MEMORANDUM

DATE: October 12, 2012

SUBJECT: Canal Plaza Hotel, Site Plan Review

DeLuca-Hoffman Associates, Inc. has reviewed the Final Level III Site Plan Application for the Canal Plaza Hotel located at the corner of Fore and Union Streets. The project consists of constructing a 123 unit select service hotel, restaurant and retail space. The project is a conversion of an existing parking lot area into building space.

C-202

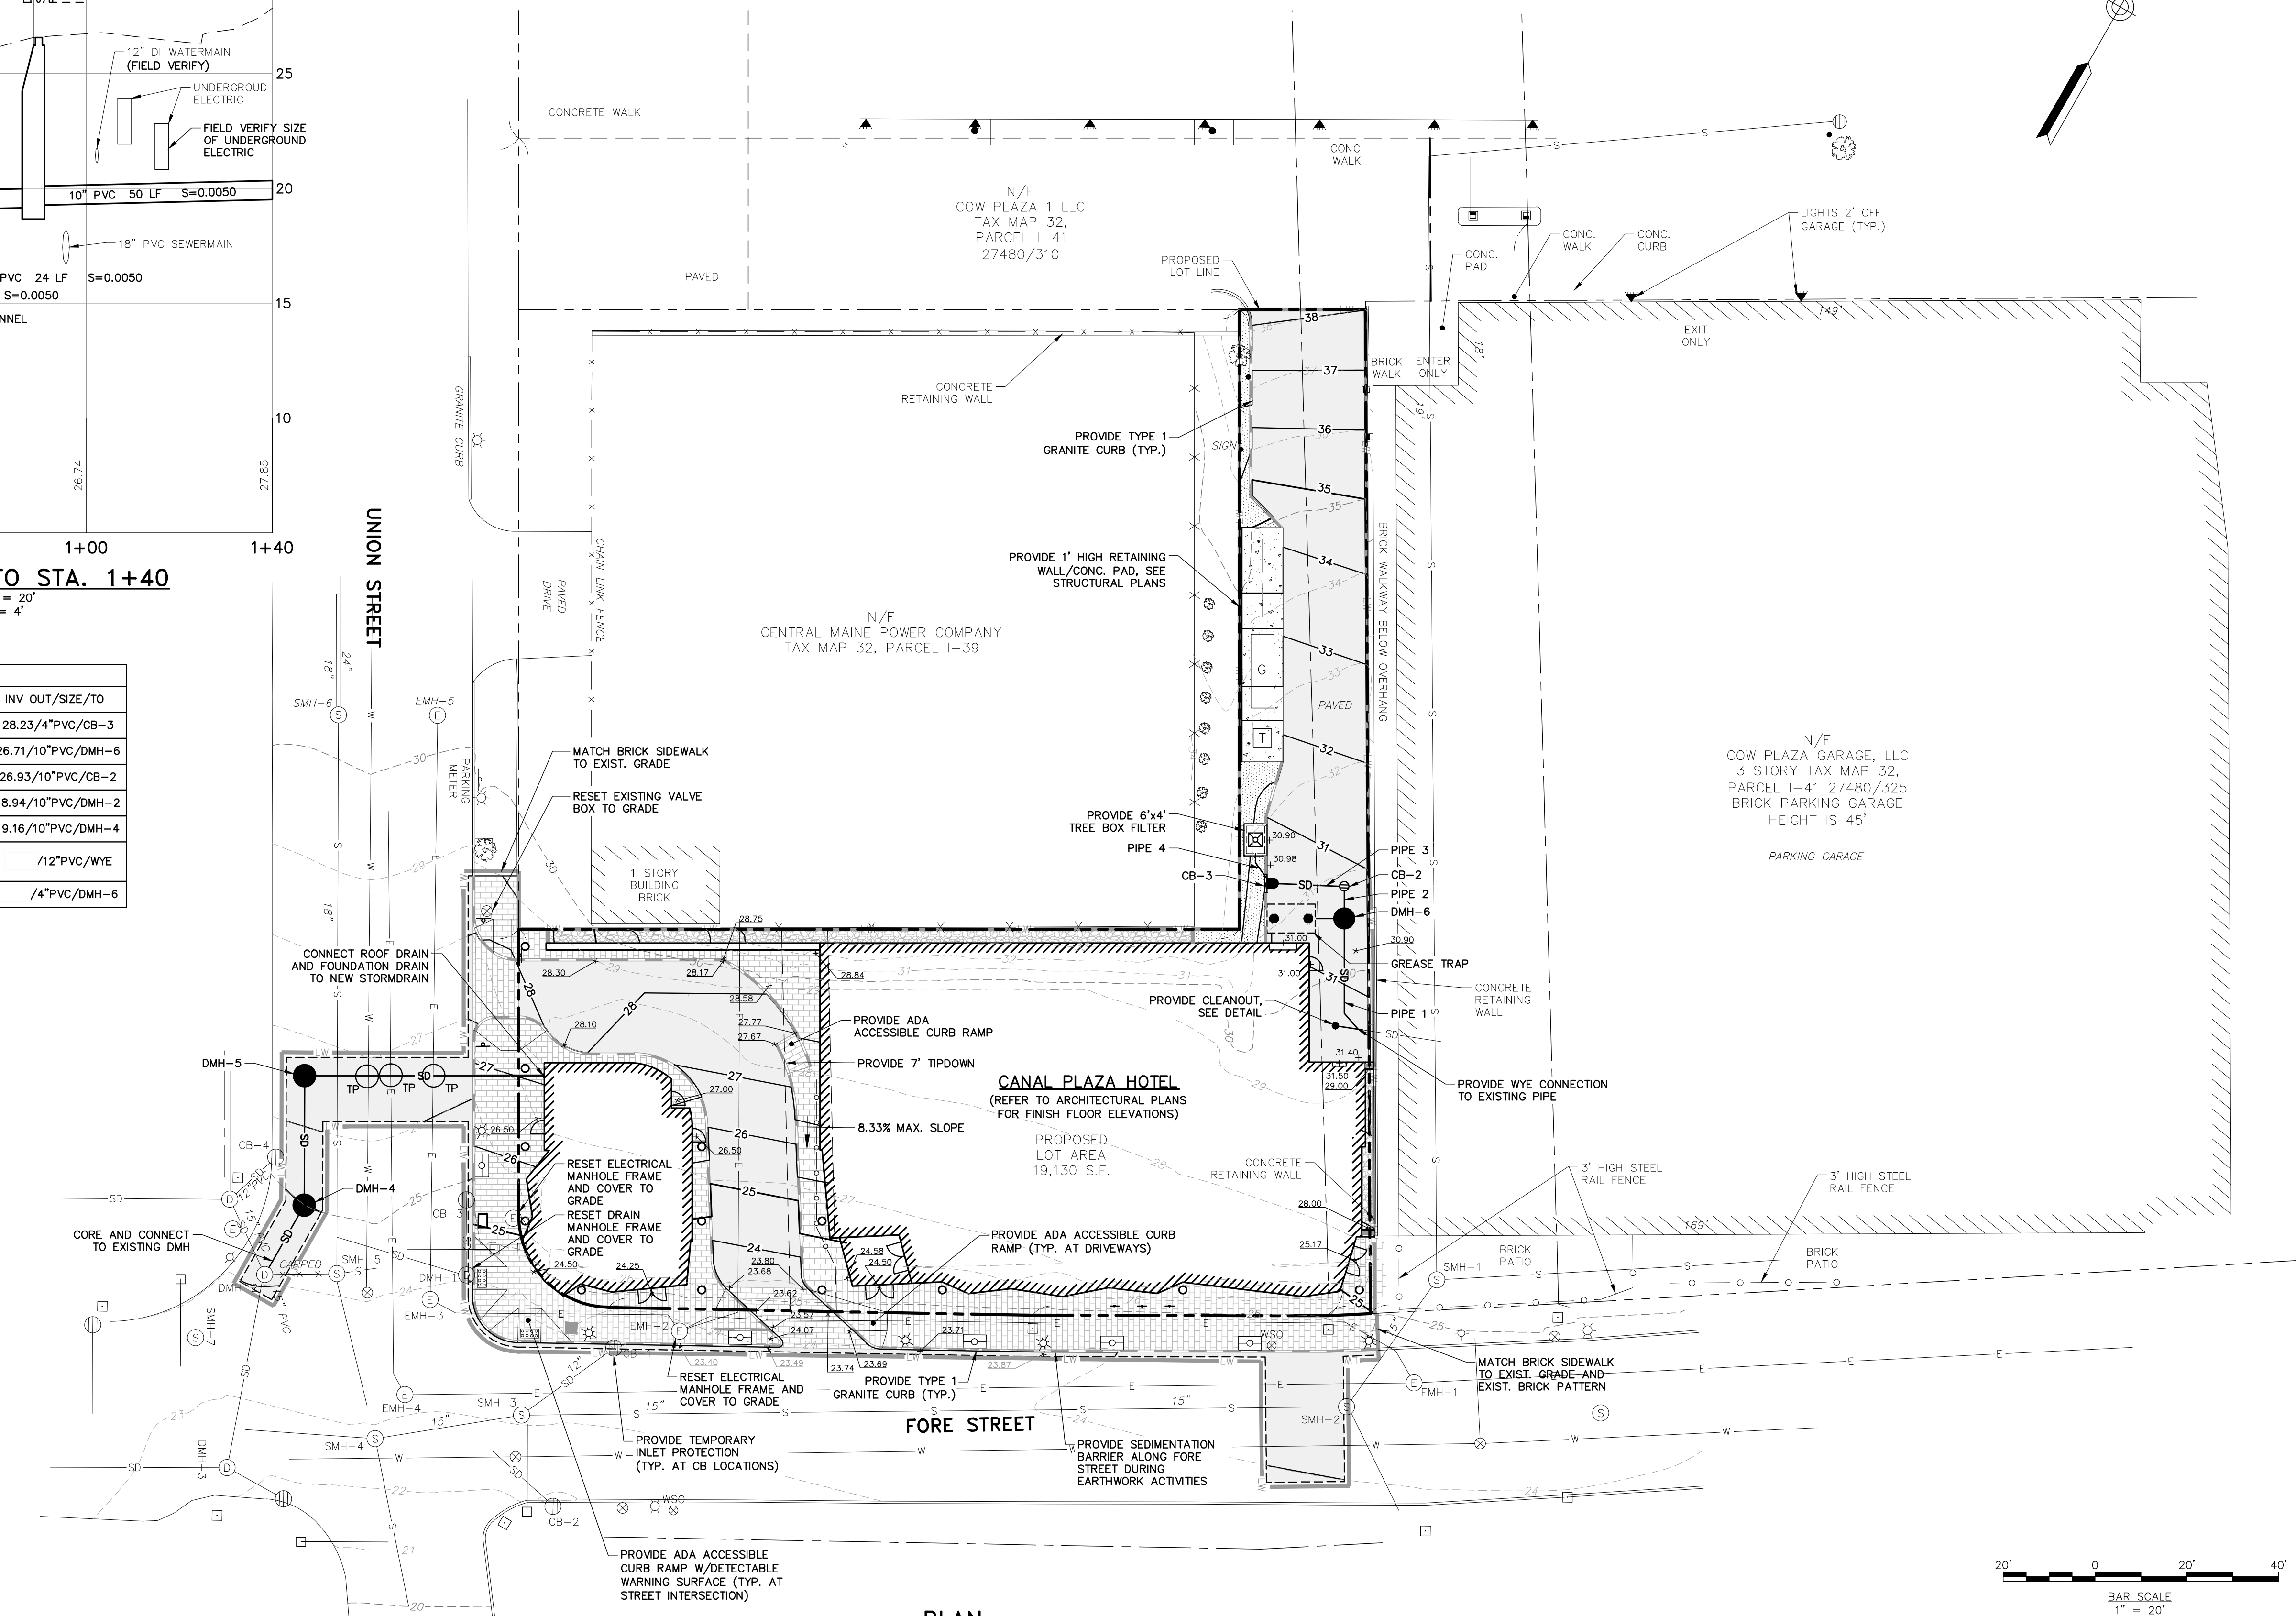
1. The current plan indicates a grease trap to be installed at the rear of the building. We assume the trap is related to the restaurant sewer service. The trap is tied into the rear drainage system, which ultimately all ties into the combined sewer pipe beneath the parking garage. Public Services should comment on their acceptance of having the grease trap tie into the drainage system. We would prefer the grease trap be tied to a sanitary sewer service lead exiting the building. The size of the grease trap should be noted.

2. The apparent pipe sizes connecting between DMH-4 and DMH-5 show up on the structure schedule and profile but not the pipe schedule. Some calculations should be provided supporting the 10" PVC pipe sizing related to the roof drain leader.

3. Public Services may want to comment on the unfortunate placement of the existing DMH-1 within the ramp on Union Street. There aren't really any options for this so you should recognize that this structure cover will be right in the middle of the ADA ramp.

4. It should be noted that the UGE along the Fore Street sidewalk and adjacent the east side of the building will be possibly conflict with the foundation construction.

5. The geotechnical report recommends the use of a foundation underdrain. The location and connection points for the foundation drain should be added to the plan.

UTILITY PLAN

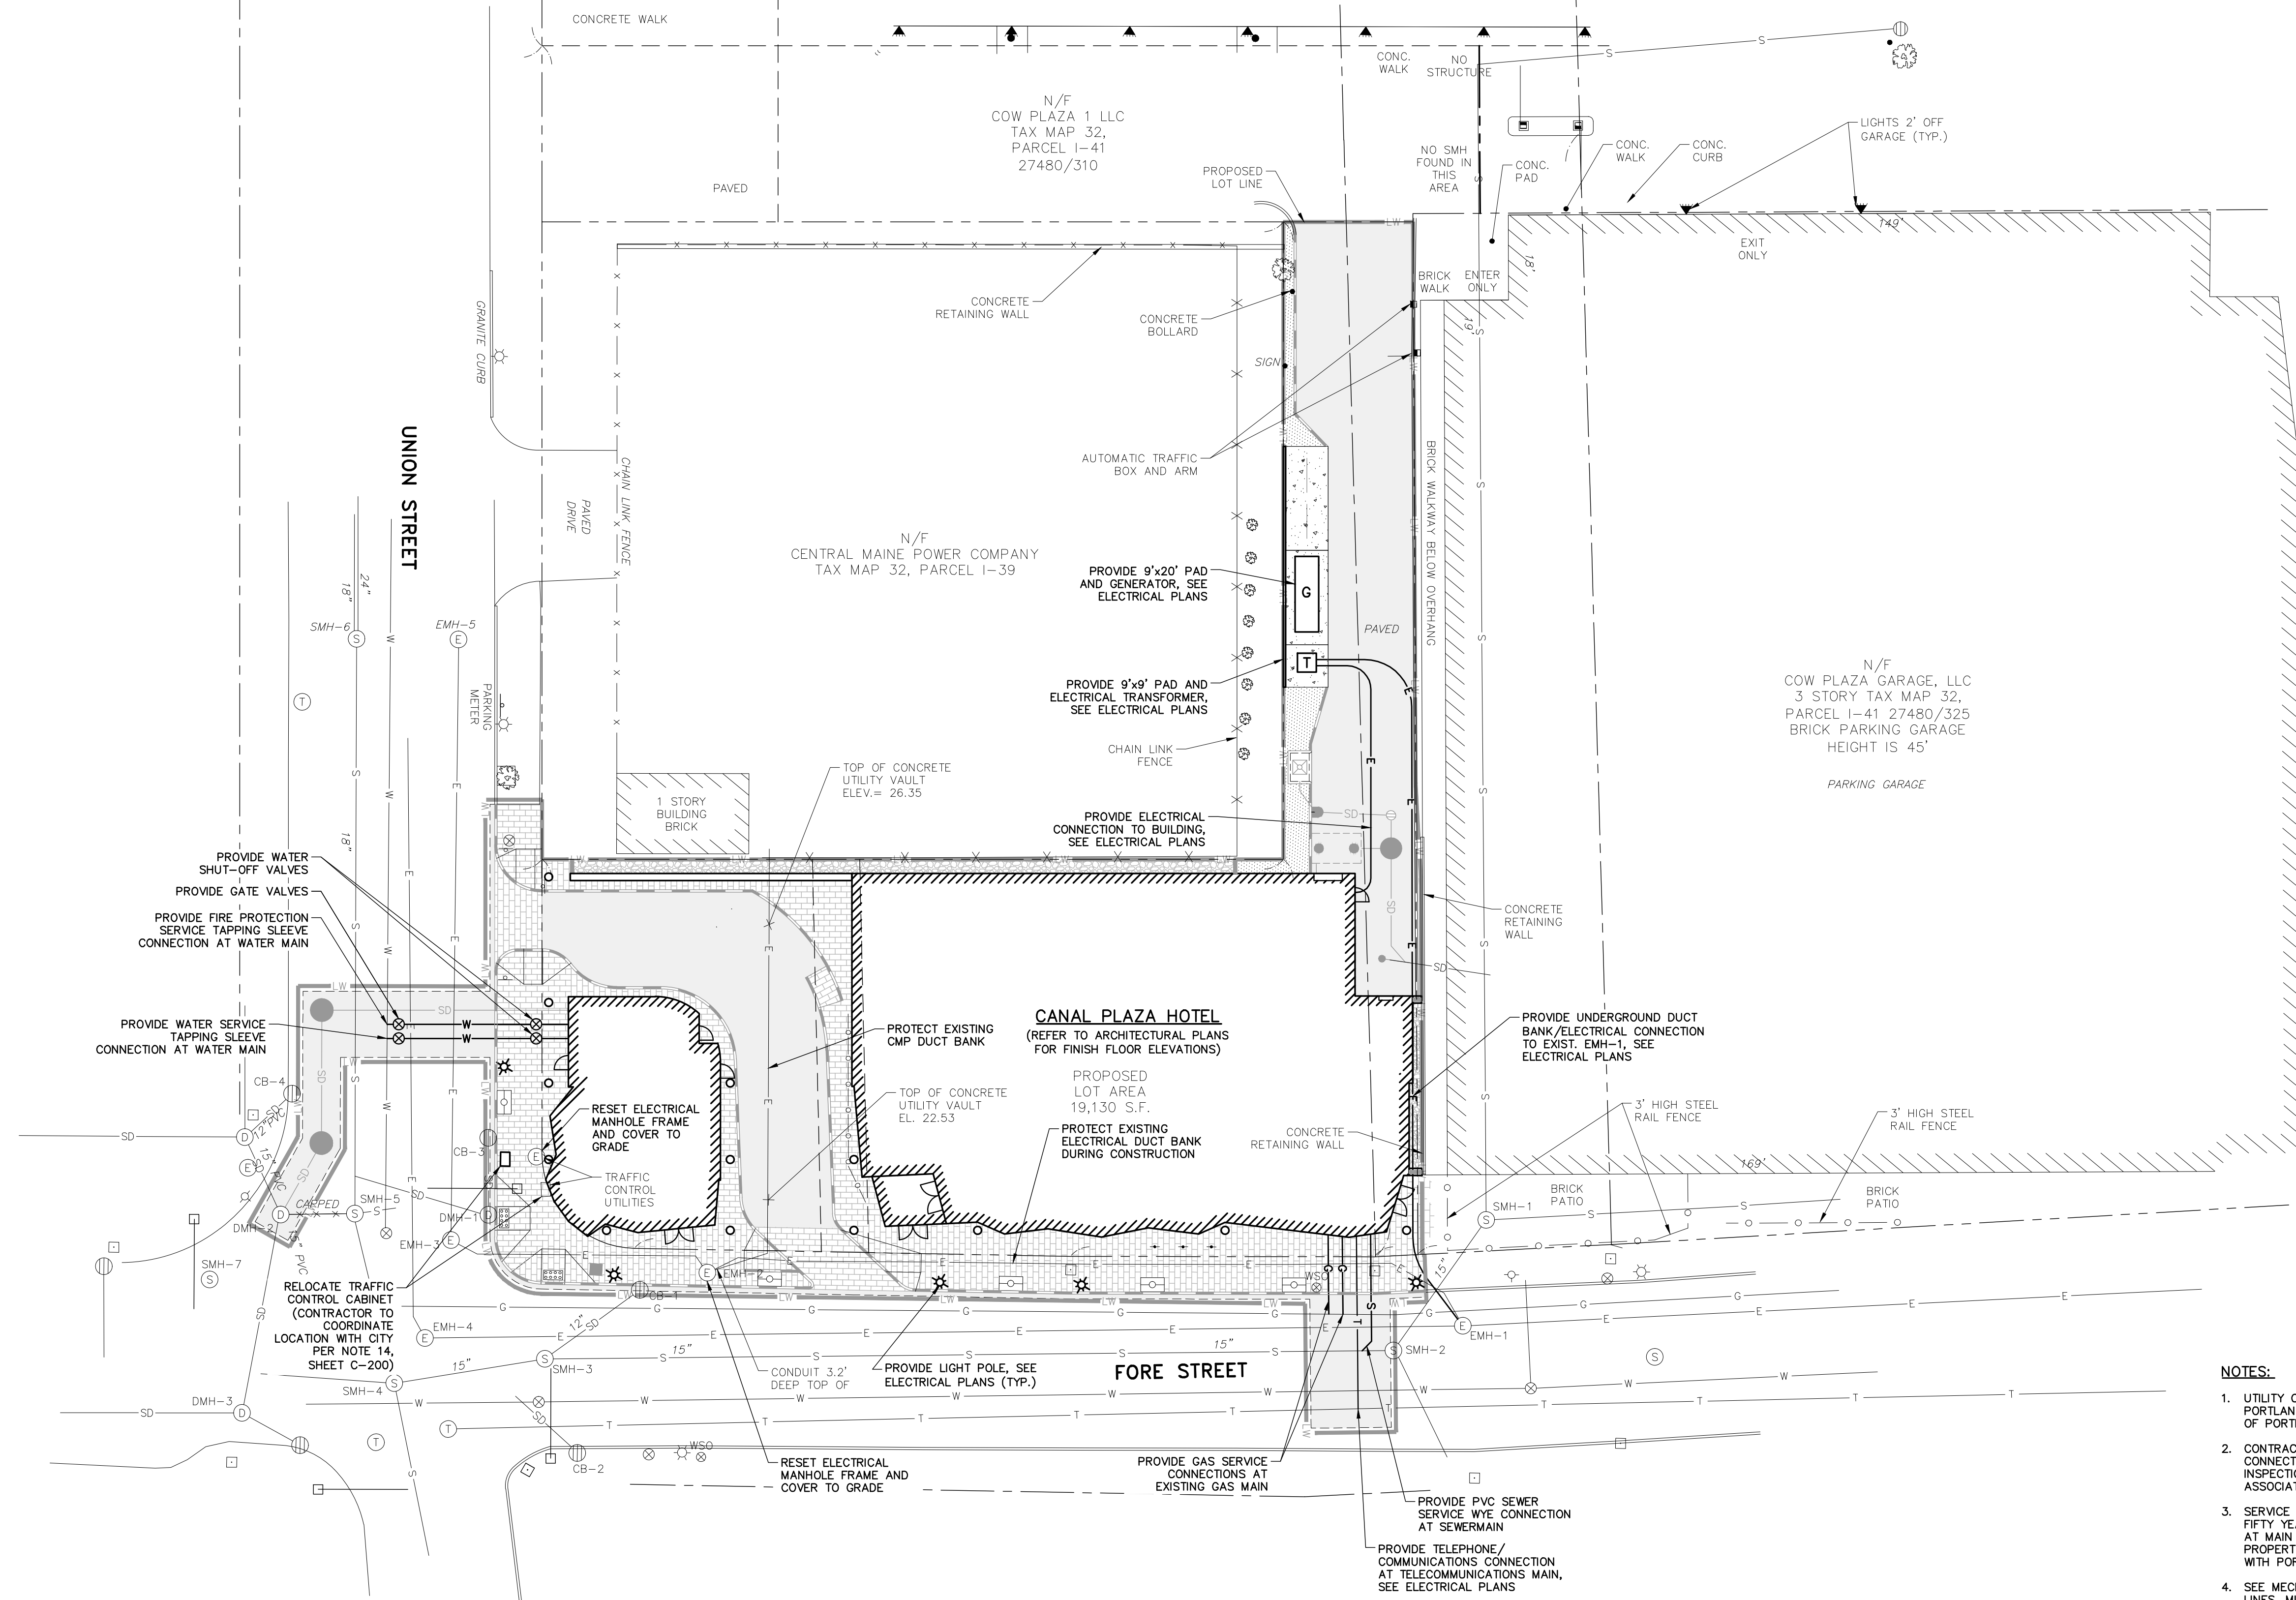
1. The engineer should confirm CMP setback requirements and sizing again for the transformer pad. Will CMP require protective bollards to the sides/front of the pad?
2. The proposed sewer service size should be identified out to Fore Street.
3. Will the emergency generator include a self-contained fuel storage or will it be natural gas fired?
4. Has CMP reviewed, and have they accepted, the location of the underground primary power supply along the easterly side of the building? Do they need an easement for the UGE primary feed?

5. It is unclear if the utilities are to be shared between the two buildings. If so, will these utility lines go underground beneath the entrance driveway? It seems like the water supply entering from Union Street can probably feed the entire building through the upper floors. However, how does the sewer for the retail space discharge? Is there a pump intended to serve the Retail bathroom since it is unlikely the plumbing can extend within the porte cochere area.
6. The fire department connection(s) should be identified as to where they will be. It appears it will be off Union Street; however this is not clearly identified on the building exterior at this location.
7. We have not reviewed any site lighting and assume this will be done by Staff. How will the street lights be powered and where will the meter be installed?
